July 22, 2021

Please see the responses to the comments received below.

LES SCHWAB TIRE CENTER CONSTRUCTION DOCUMENTS

7105 OLD MERIDIAN ROAD FALCON, COLORADO 80831

INITIAL GESC PLAN
C012

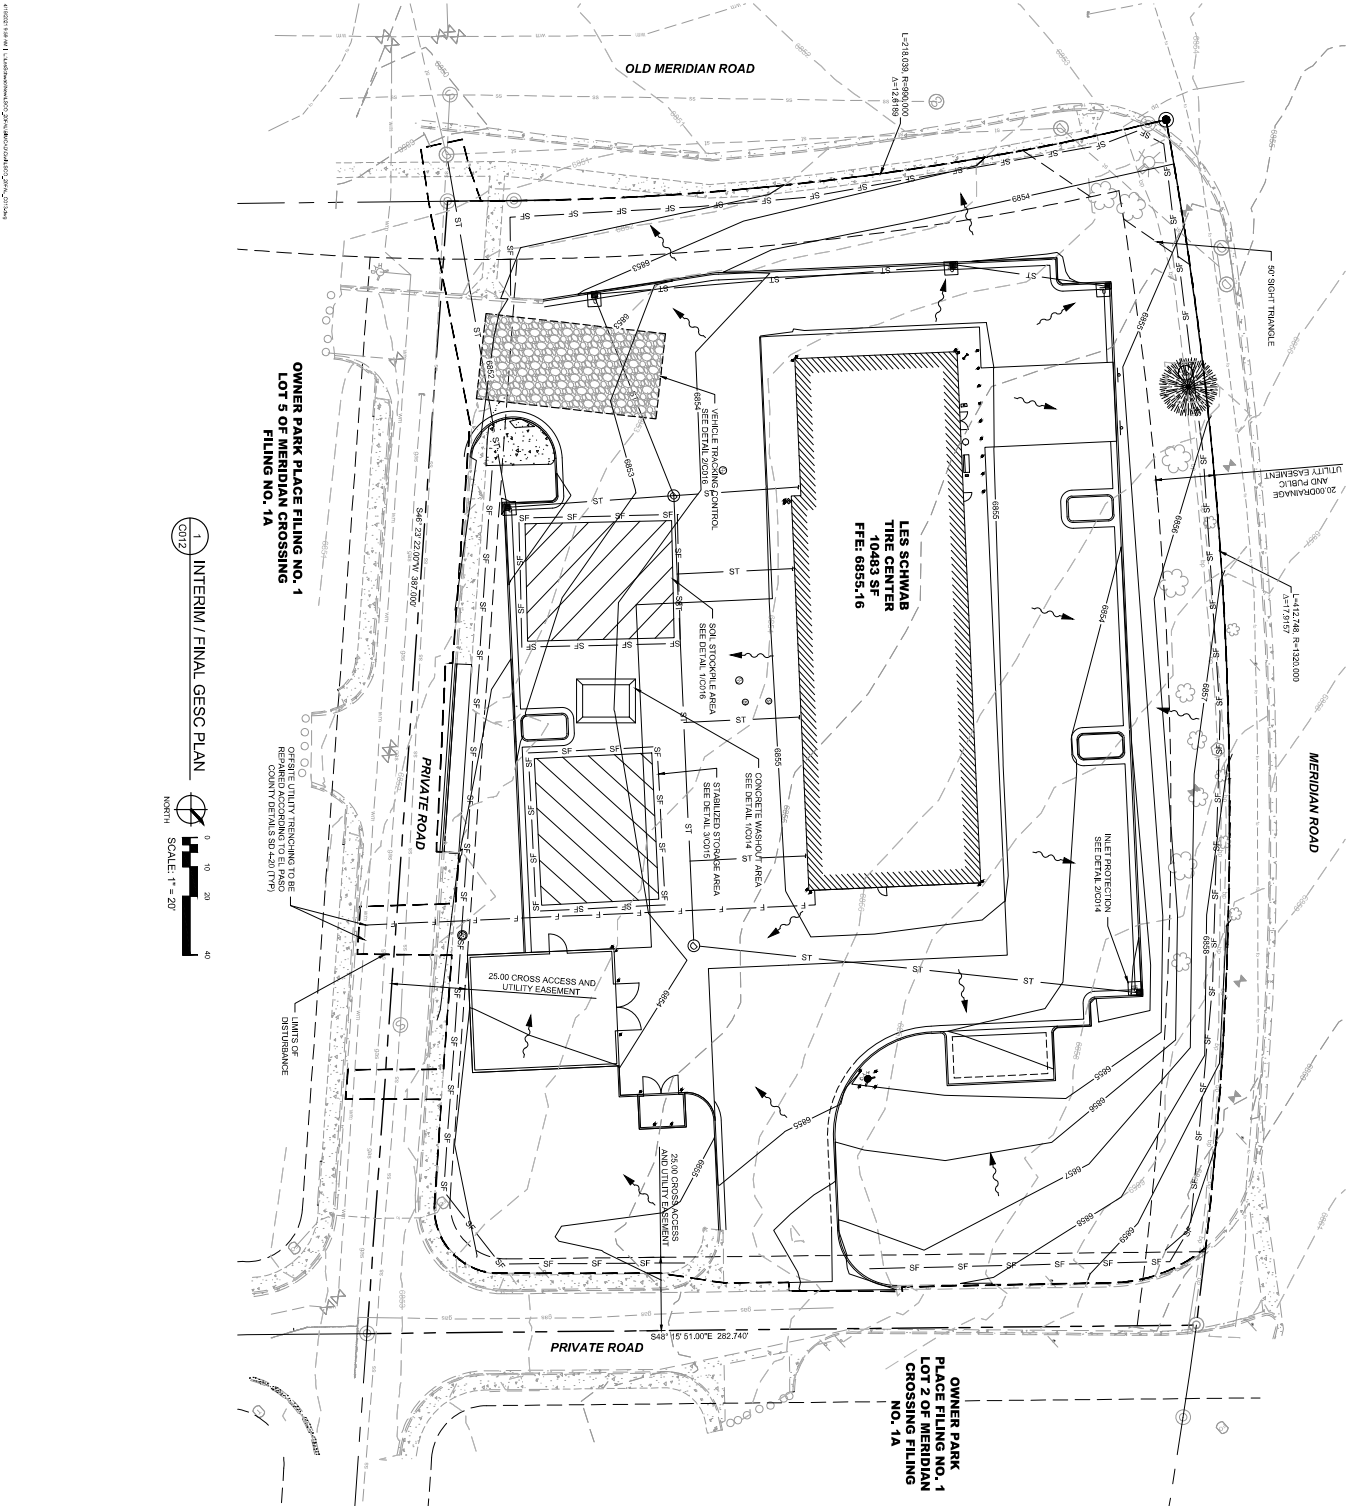
Item H and M. If "Limits of disturbance" and "construction boundary" are the same, change to "construction boundary/limits of disturbance" or otherwise show as separate linetypes for each on the legend and figure.

Note I didn't see any on this sheet of the next one. But I think it's ok. Just double check later.

Revise text to "Vehicle tracking control" to match text on the plan and detail sheet.

Checklist item "p" – delineate areas of cut and fill.

Increase to min 75ft per my comment on detail sheet below.

Label existing bollards to be removed per site dev plan.

Checklist Item "o" – clearly callout offsite grading. Note that the contractor may need to obtain and EPC "Work in the ROW" permit.

Response: Limits of disturbance label has been changed to read "LIMITS OF DISTURBANCE / CONSTRUCTION BOUNDARY"

Response: Rock sock has been removed from legend.

Response: Legend has been revised.

Response: see sheet C017

Response: Vehicle tracking length increased to 75'

Response: Existing bollards to be removed callout added.

Response: Offsite grading for utility trenching noted to match existing grades.

CUT/FILL GESC
EXHIBIT
C017

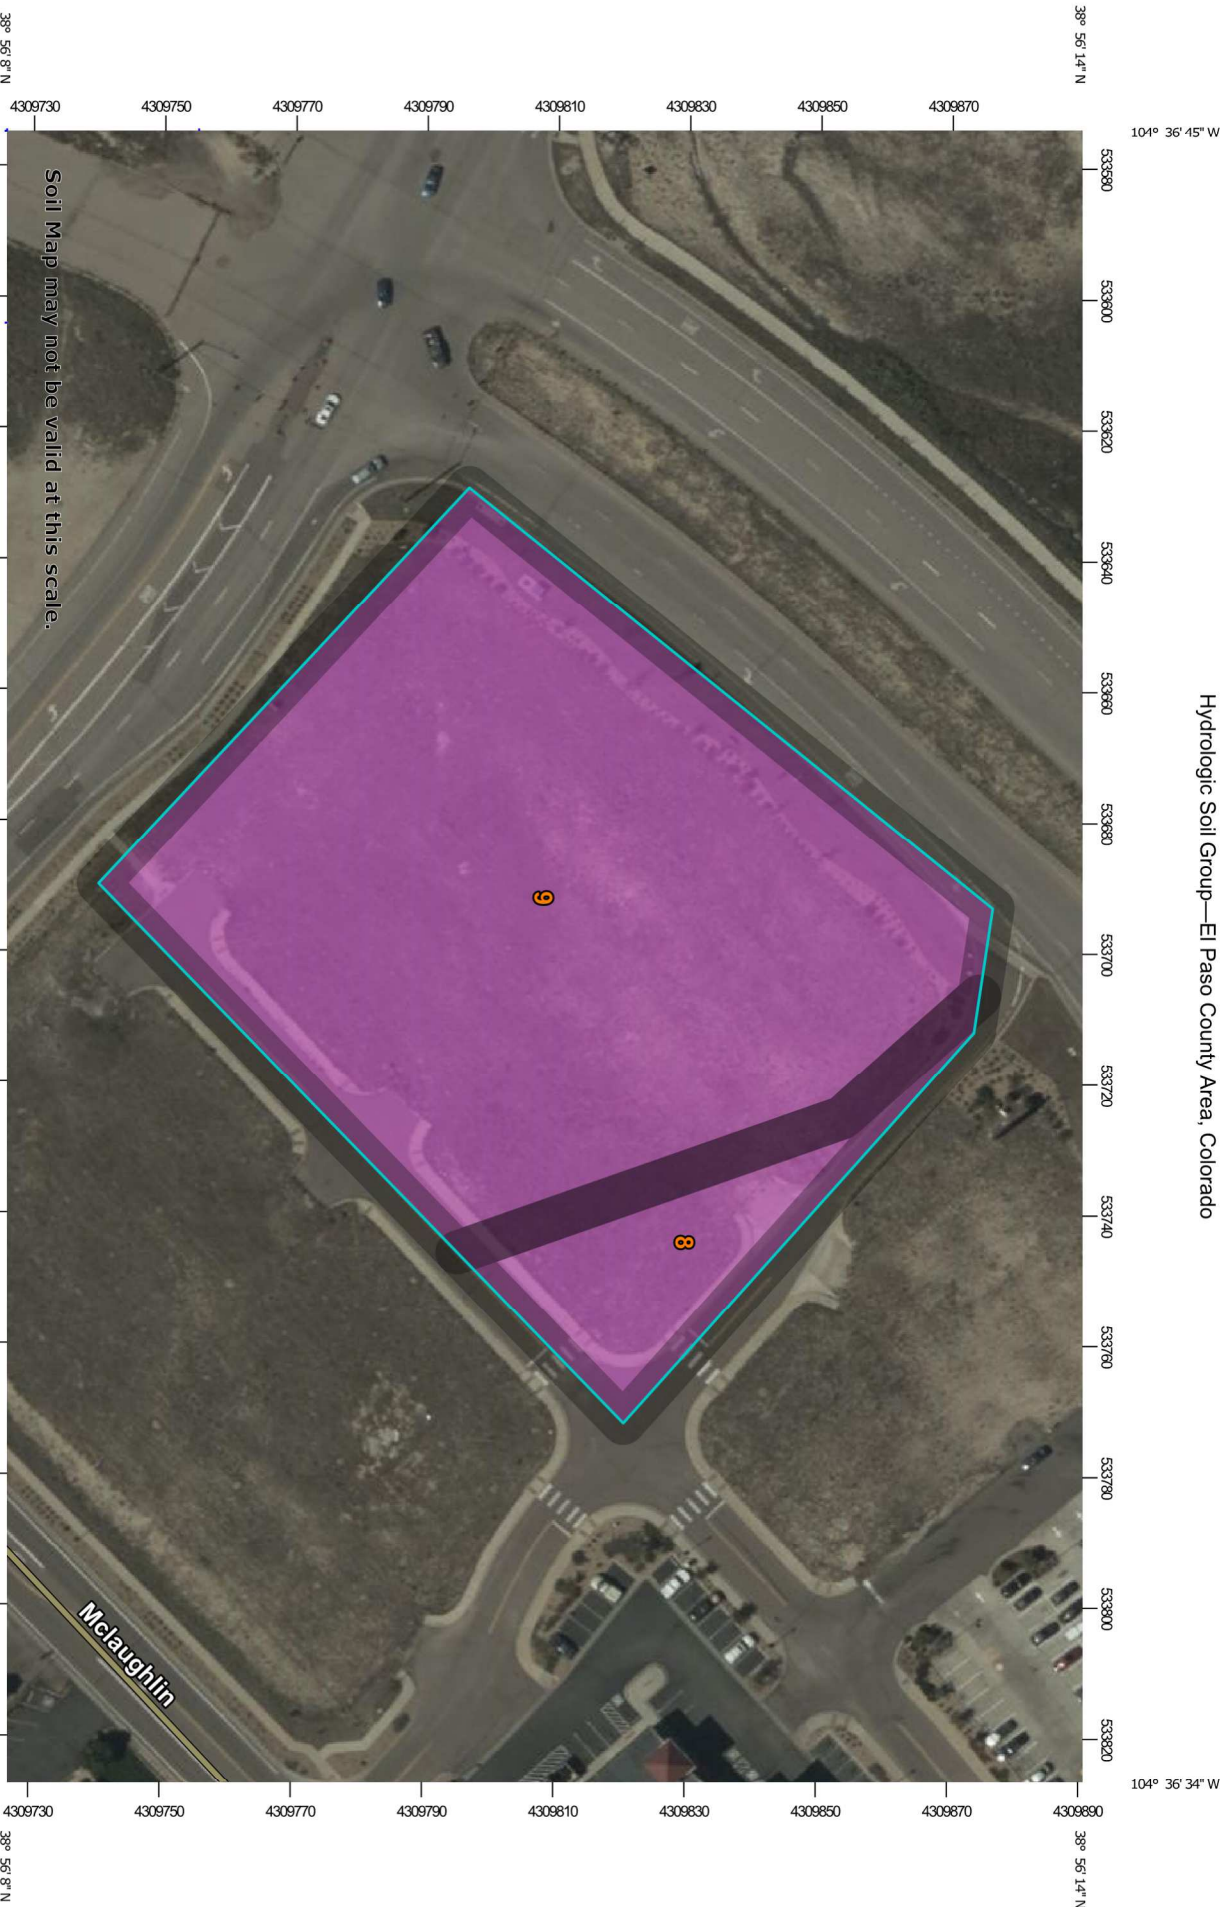
Add areas of cut and fill identified

Response: See sheet C017

**C100**

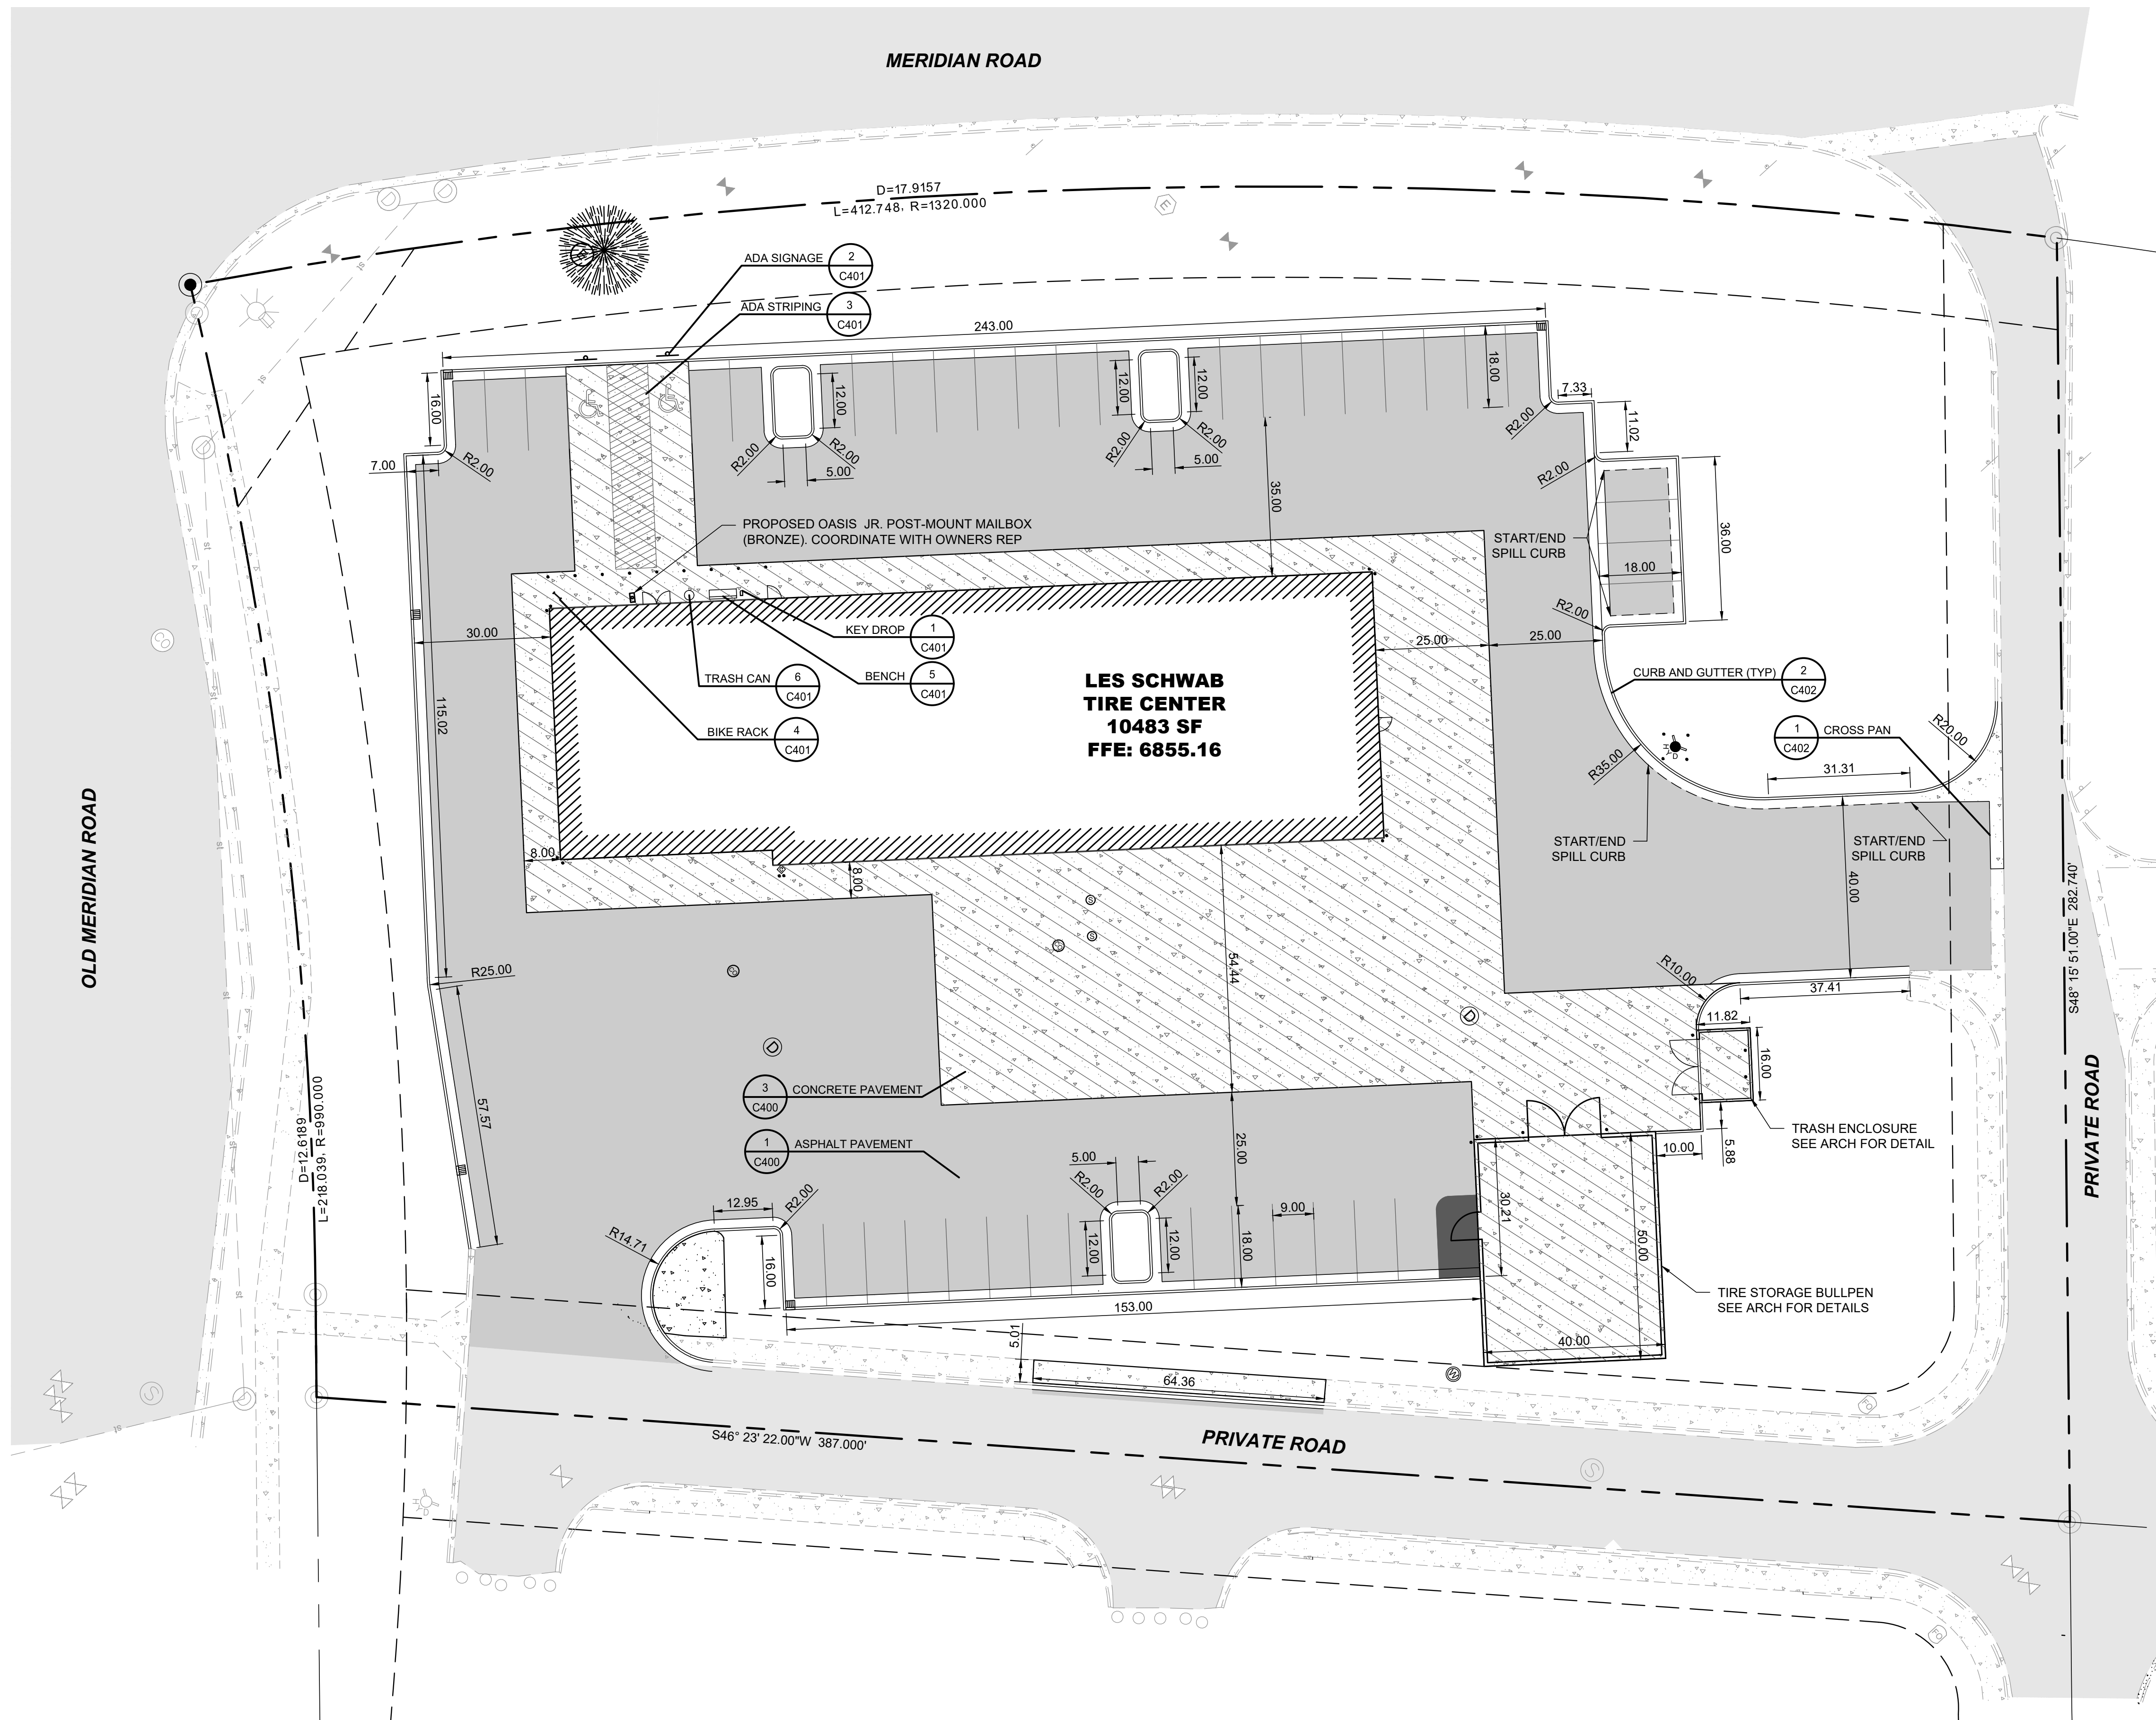
Please provide a site data table. The site data table should include: property address and parcel ID, land use, zoning, lot area, building height, parking (required vs. proposed). Review the dimensional standards included in Chapter 5 and verify all dimensional standards are met.

Response: Site data table has been added to sheet C100.
